19 March 2021  
Ref: RH/Let/P1483ii

**RE: Section 73 Variation of Condition Application: Proposed Variation of Condition 1 pursuant to Planning Permission A/166/19/RES at The Laurels, Dappers Lane, BN16 4EN.**

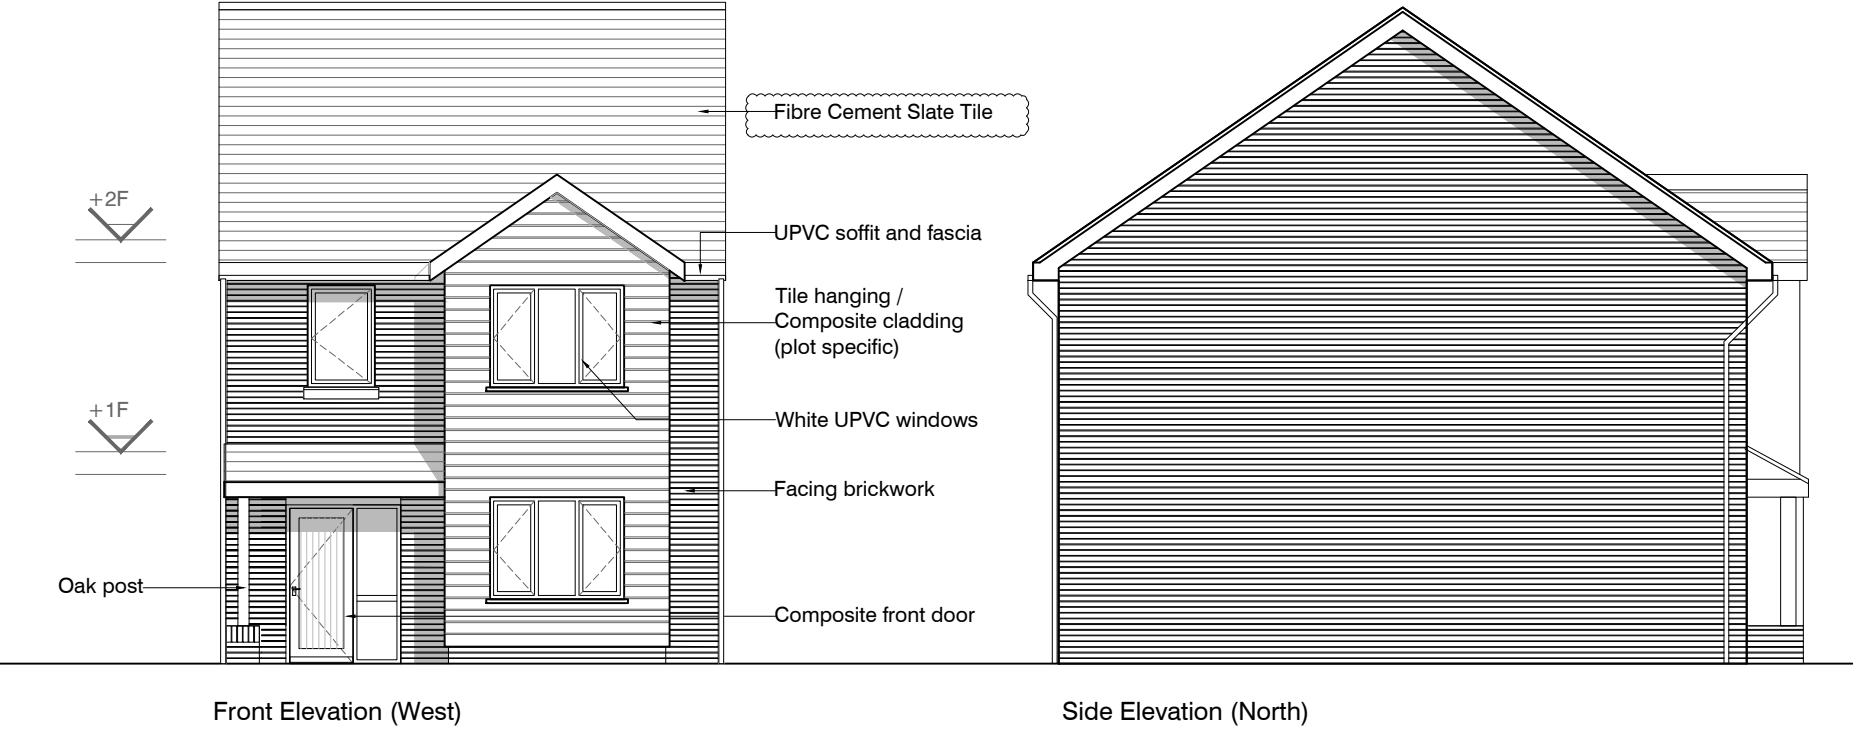
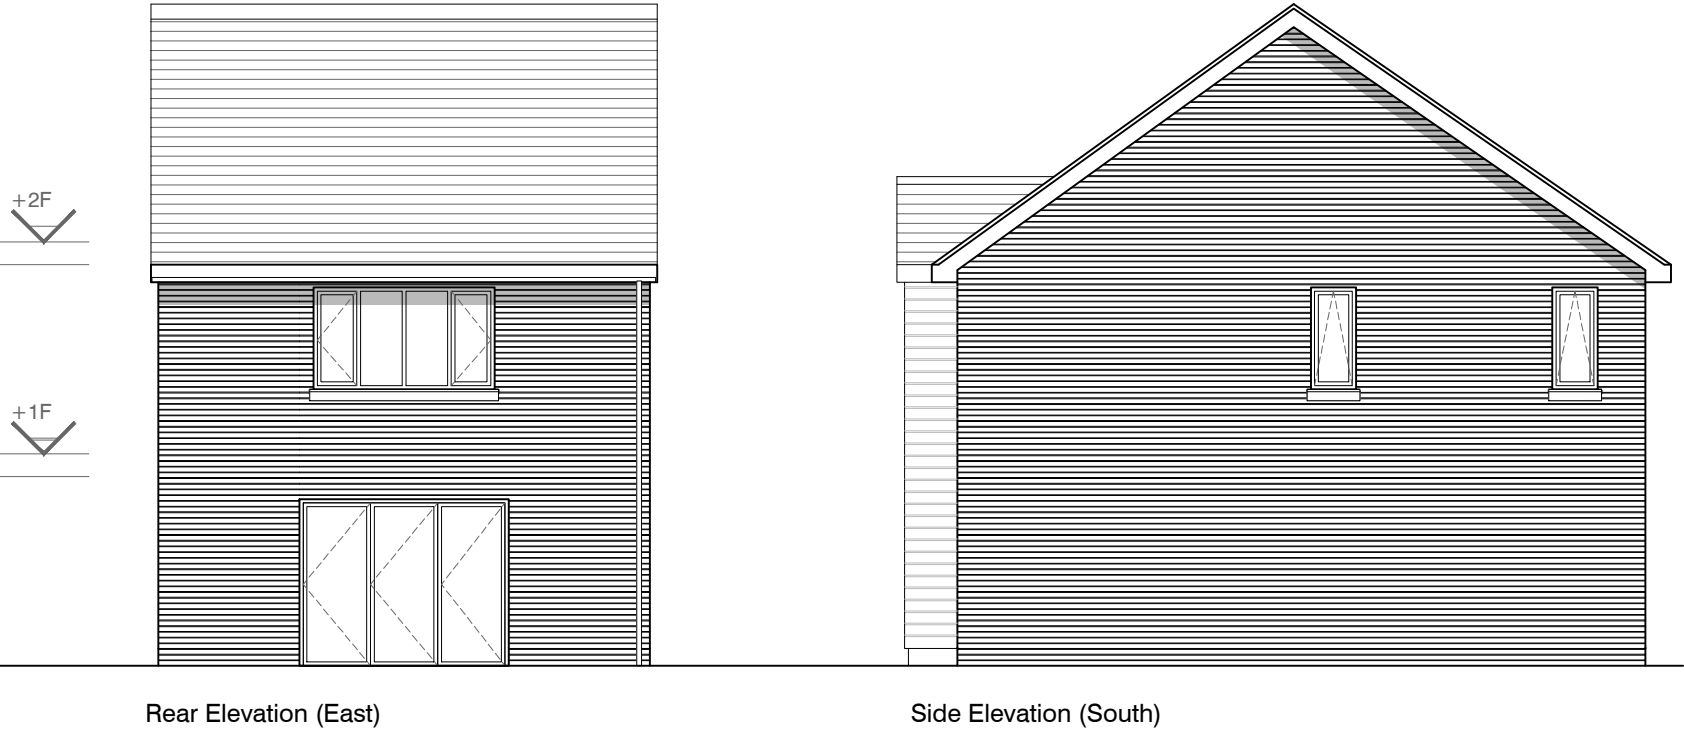
The Applicant would like to amend the materials proposed for the roofing tiles from "Marley Eternit Acme Single' Camber Mixed Brindle S/C K3" to "Marley Eternit Thrutone Fibre Cement Slate Roof Tile" on **Plots 4, 5, 7, 9**. This would affect drawing references 0310-P011, 0310-P013 and 0310-P021 only.
